**REQUEST**

Current Zoning: NS HDO (neighborhood services, historic district overlay)  
Proposed Zoning: NC(EX) HDO (neighborhood center, exception, historic district overlay)

Approximately 0.517 acres located at the southeast intersection of Cleveland Avenue and East Worthington Avenue, south of East Boulevard.

The petition proposes to allow neighborhood center uses in the existing building on the site in addition to the relocation of the historic Leeper & Wyatt building to the portion of the site that is currently utilized as surface parking.

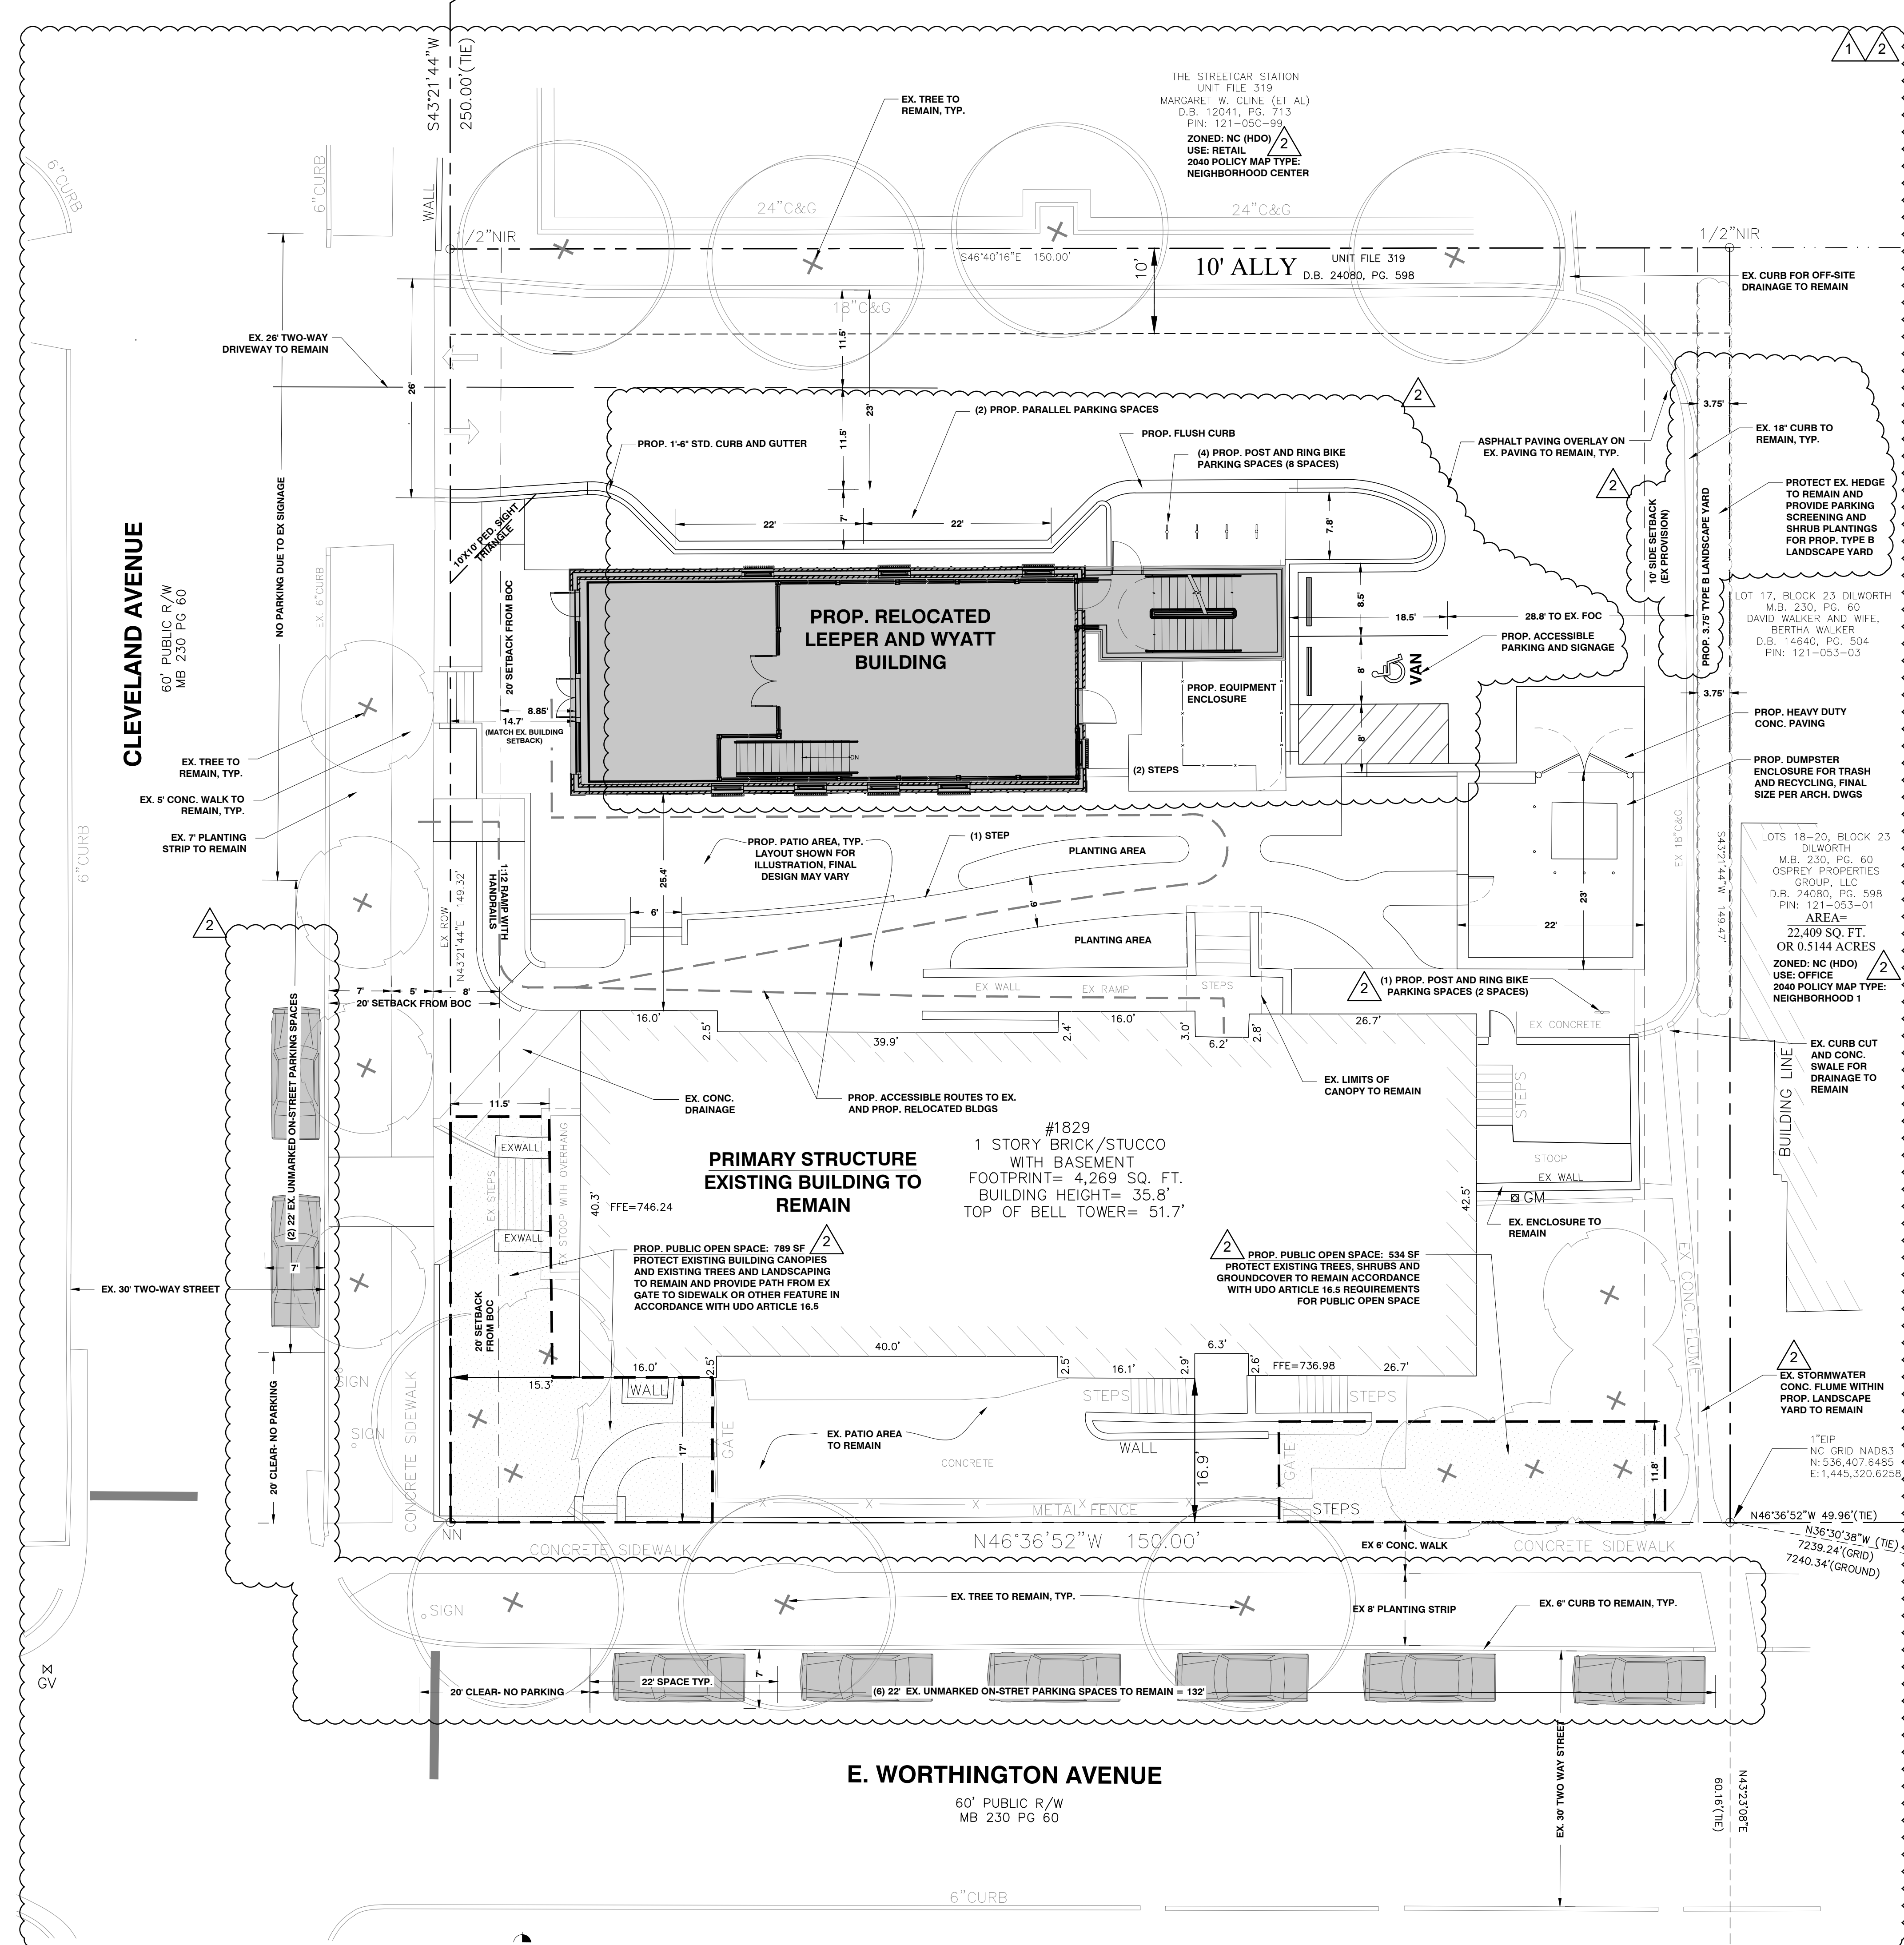
1. Cleveland Avenue and Worthington Avenue are both shown as 30' wide streets on current site plans. These streets must be at least 41' wide from back of curb to back of curb per CLDM U-05. Additionally, each road must label and dimension future back of curb location to the centerline.

5. Revise the site plan to show the centerline on each public street. Dimension the right-of-way and the back of curb from the centerline.

6. Update labeling on the site plan to list the setback against the N1 parcel as the rear setback rather than side setback.
7. Update the wording in the parking summary table to clearly distinguish between ordinance requirements, and the various types of parking being provided. The ordinance requires 22 *off-street* spaces for restaurant/bar uses, what is being provided through the EX provision is 4 *off-street* spaces. Separately from that, the proposal includes 8 on-street spaces and 10 off-site leased spaces. Rather than listing out the parking as being in the two categories of on-site and off-site, it should be listed as off-street, on-street, and off-site leased spaces.
